WEST SUSSEX COUNTY COUNCIL CONSULTATION

TO:	Arun District Council FAO: Simon Davis
FROM:	WSCC - Highways Authority
DATE:	10 June 2020
LOCATION:	Land west of Fontwell Avenue, Eastergate, PO20 3RX
SUBJECT:	BN/50/20/PL Demolition of existing structures onsite & erection of 42 No. dwellings with access, parking, landscaping & associated works. This application is a Departure from the Development Plan.
RECOMMENDATION:	More Information

Transport and highway Access Design drawing showing proposed access details to the site

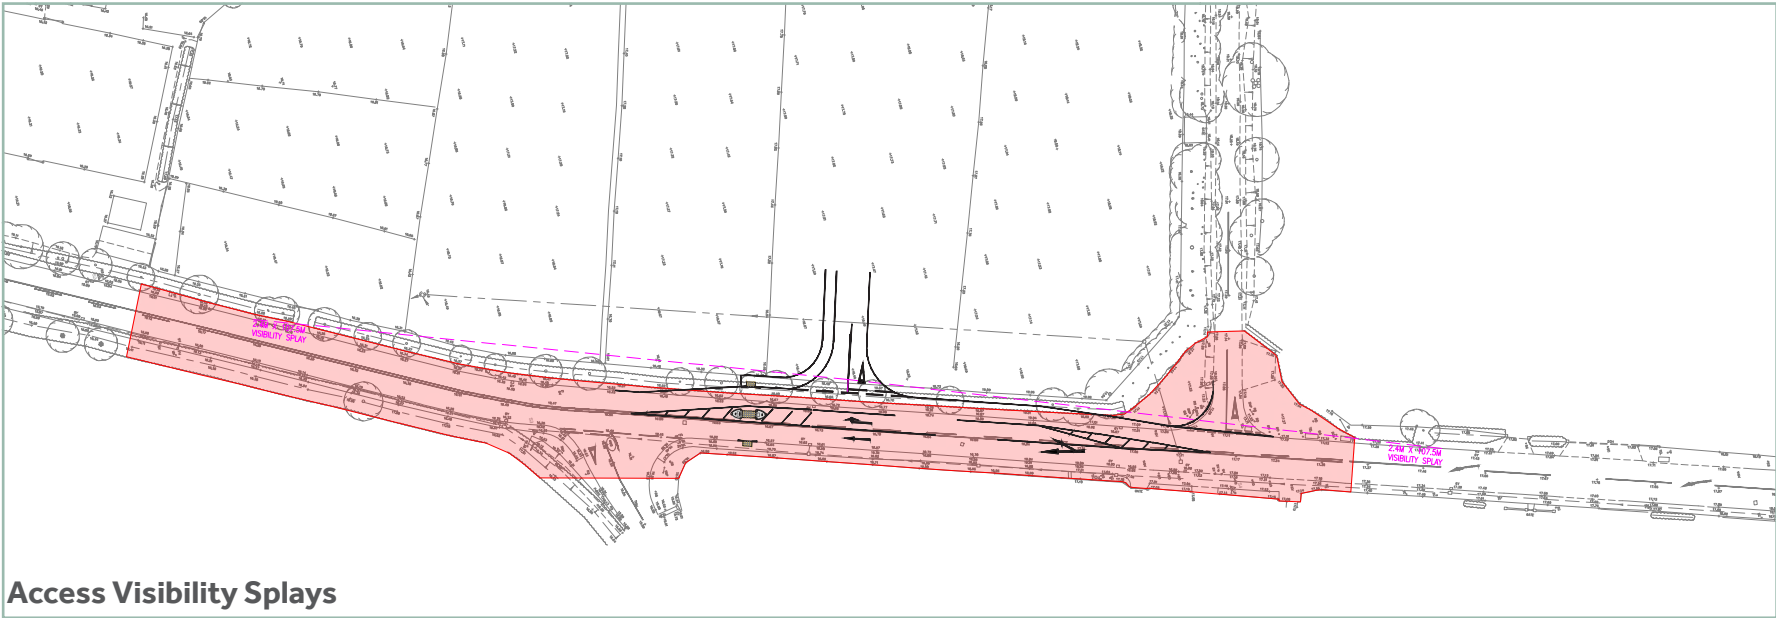
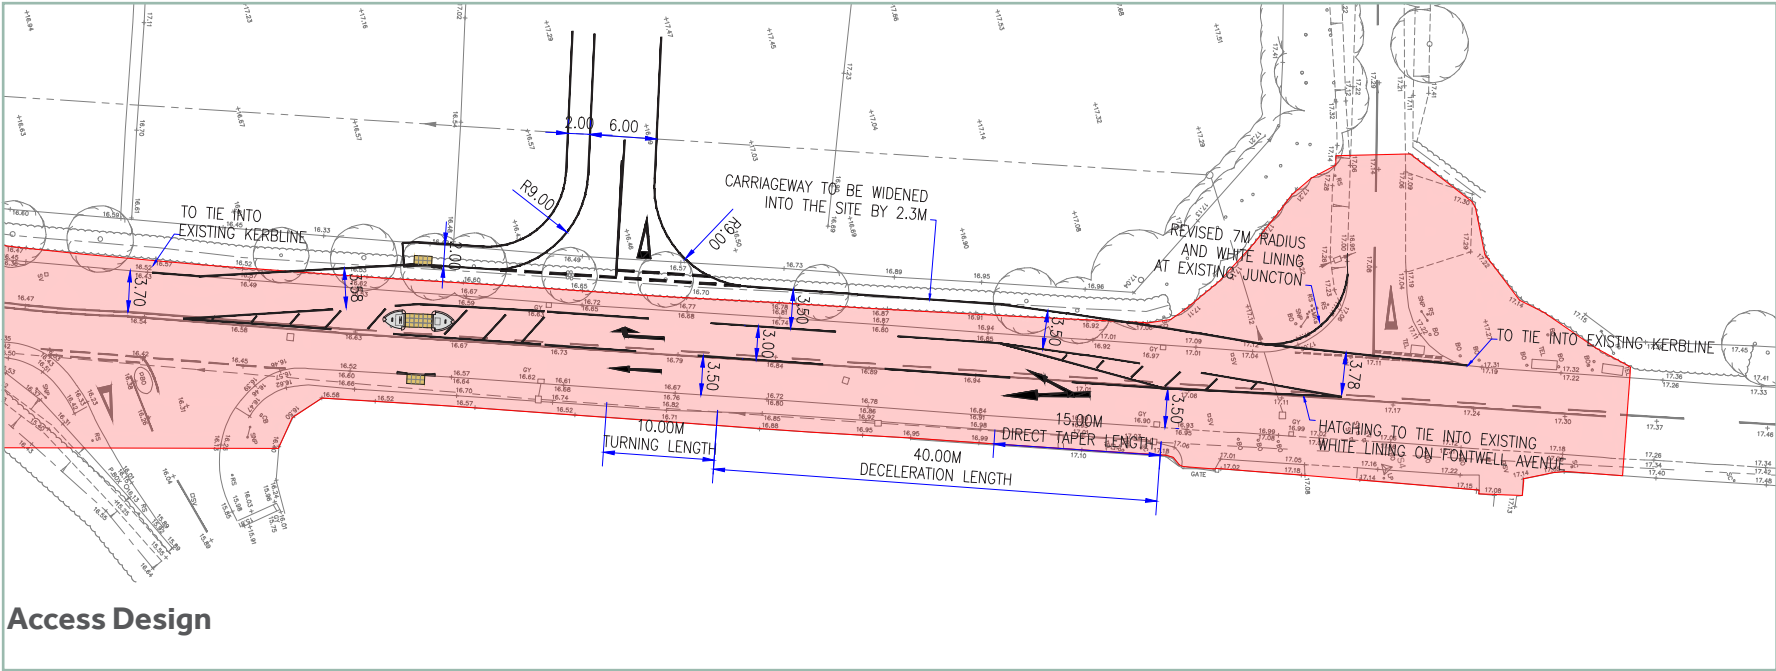
It is acknowledged that the Access Design drawing details the proposed highway modifications, including features of the right hand turn lane and slight amendments to southern radius of the Level Mare Lane/ Fontwell Avenue junction. Nonetheless, a full Design Audit of all proposed highway modifications should be provided in order to comprehensively detail each design standard applied and reference to clause this meets within the Design Manual for Roads & Bridges (DMRB). This process will also allow any Departures from Standard (DfS) to be identified.

With slight alterations to southern radius of Level Mare Lane/ Fontwell Avenue junction it has been demonstrated that visibility of 2.4m by 107.5m in line with 85th percentile speeds can still be achieved.

The auditor states that with widening on western side of Fontwell Avenue the visibility splay for Level Mare Lane 'does go to the western kerbline' and that an area of carriageway could be hidden and could obscure cyclists etc. The auditor recommends that the visibility splay should extend to the western kerbline. The DR does not appear to have addressed this point however the LHA note that the Level Mare Lane visibility plan does show the splay extending to the western kerbline. It is advised that the DR is updated to address and reflect this.

Site Block Plan

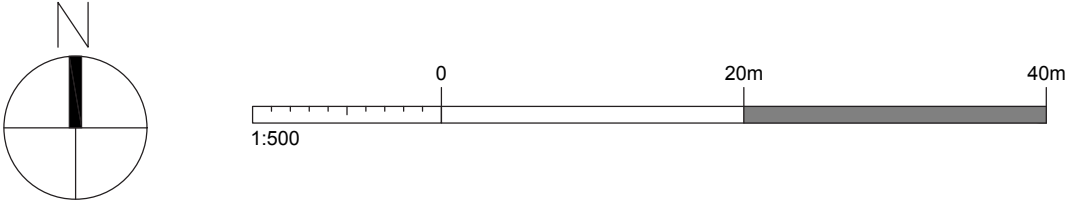
A pedestrian access from the northern boundary of the site will link to Level Mare Lane as indicated on the Site Layout plan. Other plans provided such as Block Plan do not make this link clear. The applicant should clarify. Considering the anticipated low traffic flows on Level Mare Lane, a connection for pedestrians without further infrastructure is considered appropriate in this case.
